**Addendum No. 1**

RE: Contract # C204795

**Columbus County (BR-0073)**

BRIDGE #230005 OVER GAPWAY SWAMP ON US-76.

REVISIONS						SHEET NO.
NO.	BY:	DATE:	NO.	BY:	DATE:	S-5
1			3			TOTAL SHEETS
2			4			38

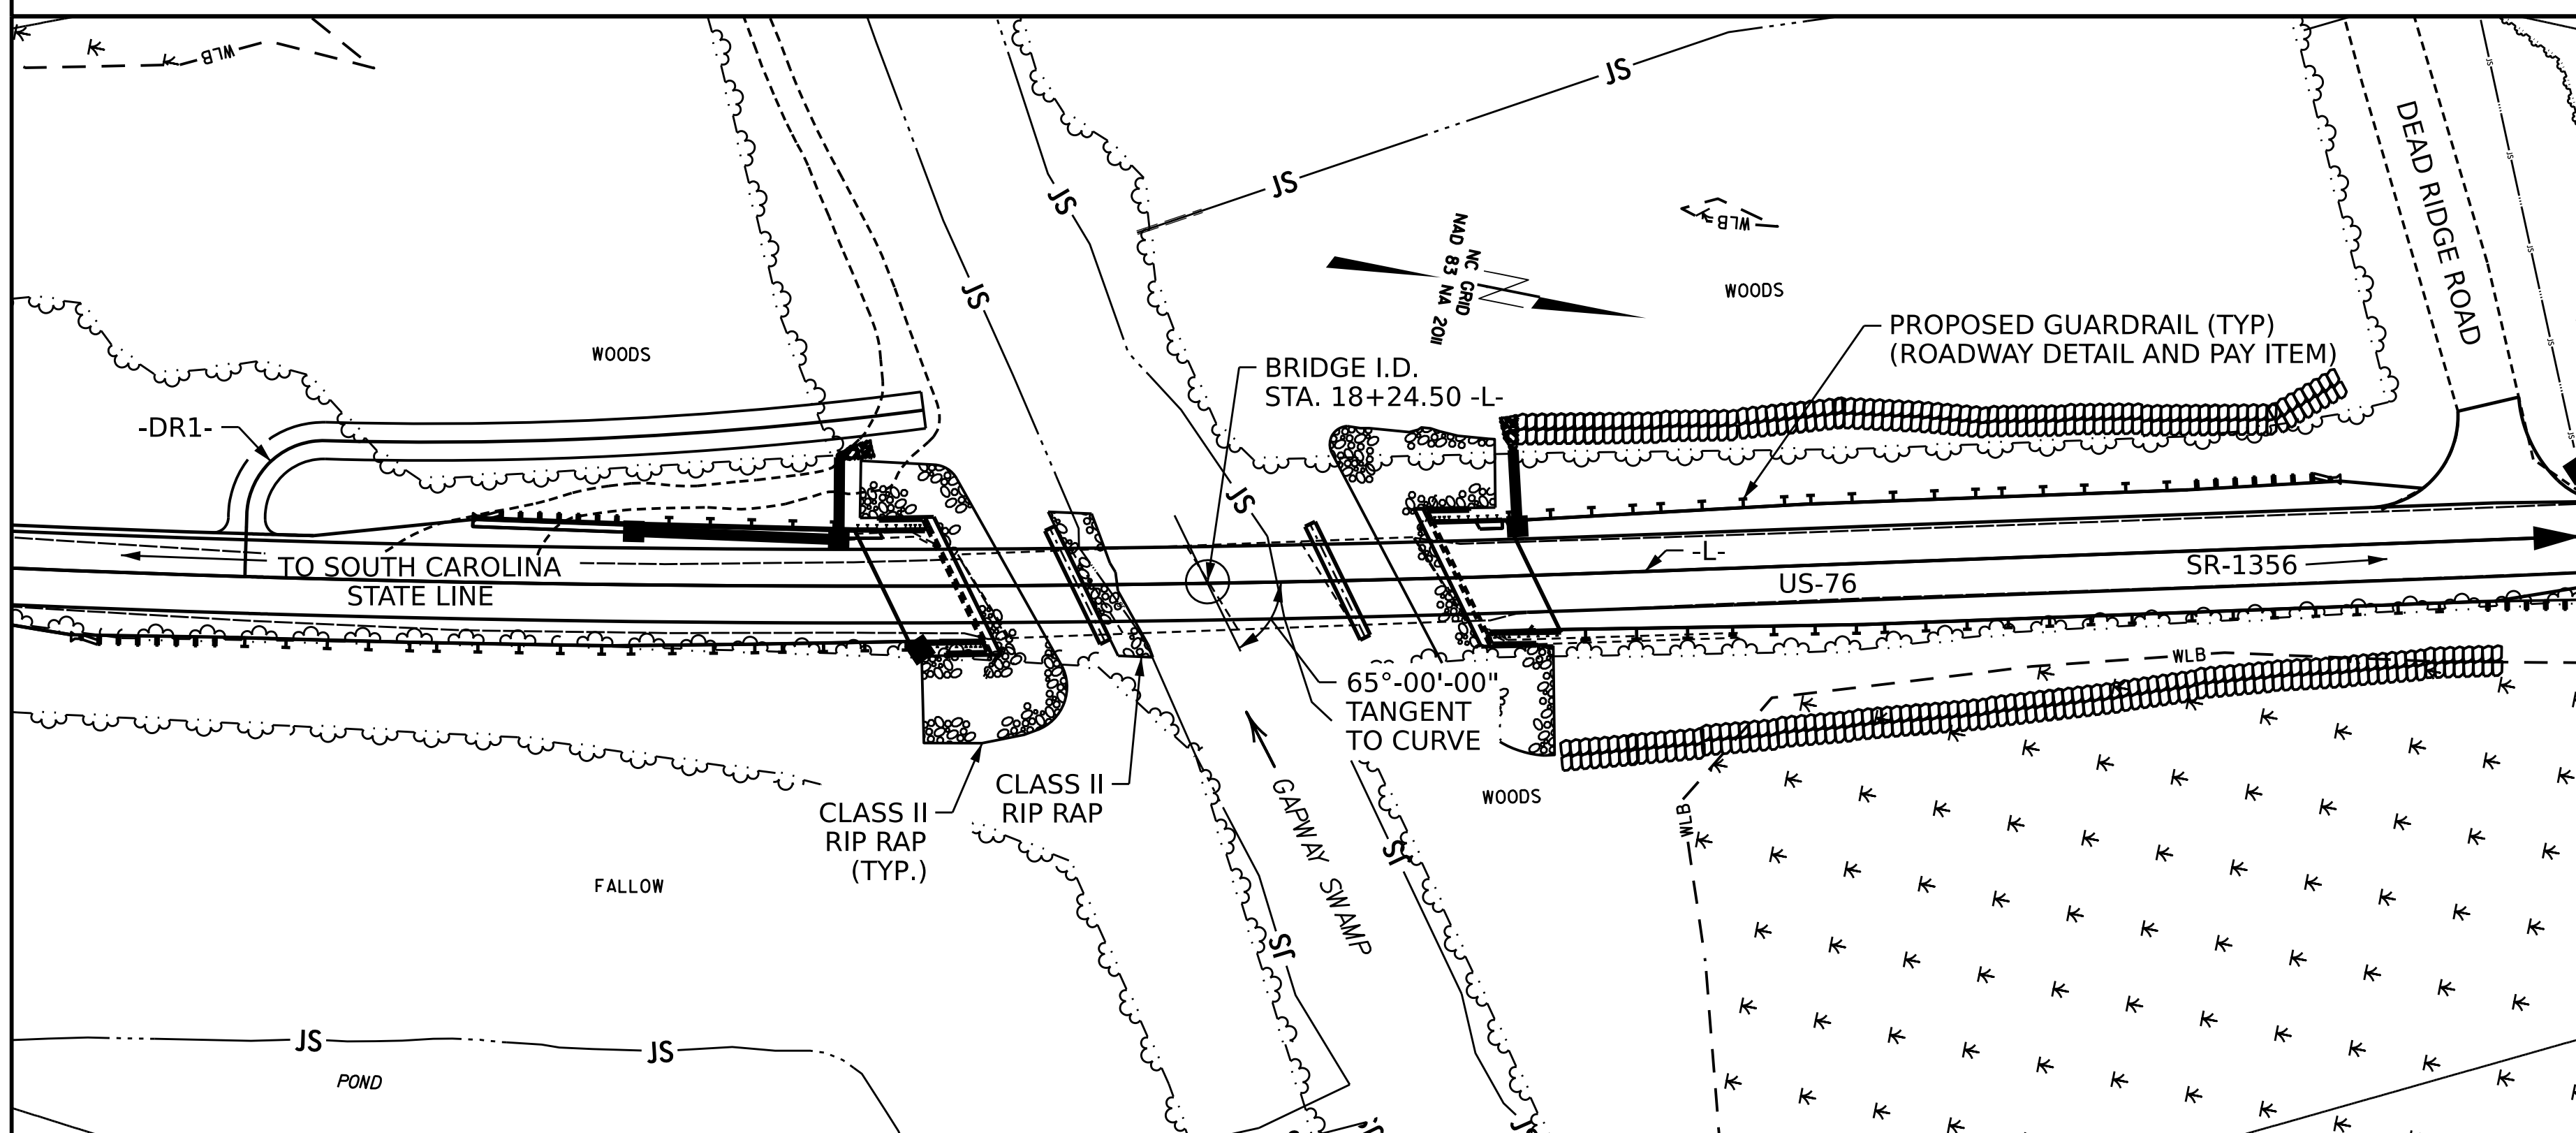
Sheet No.	Revision
S-5	Bill of Material updated to reflect quantity change below.

<u>Item</u>	<u>Description</u>	<u>Old Quantity</u>	<u>New Quantity</u>
0090-8147000000-E 420	REINFORCED CONCRETE DECK SLAB	3,682 SF	6,382 SF
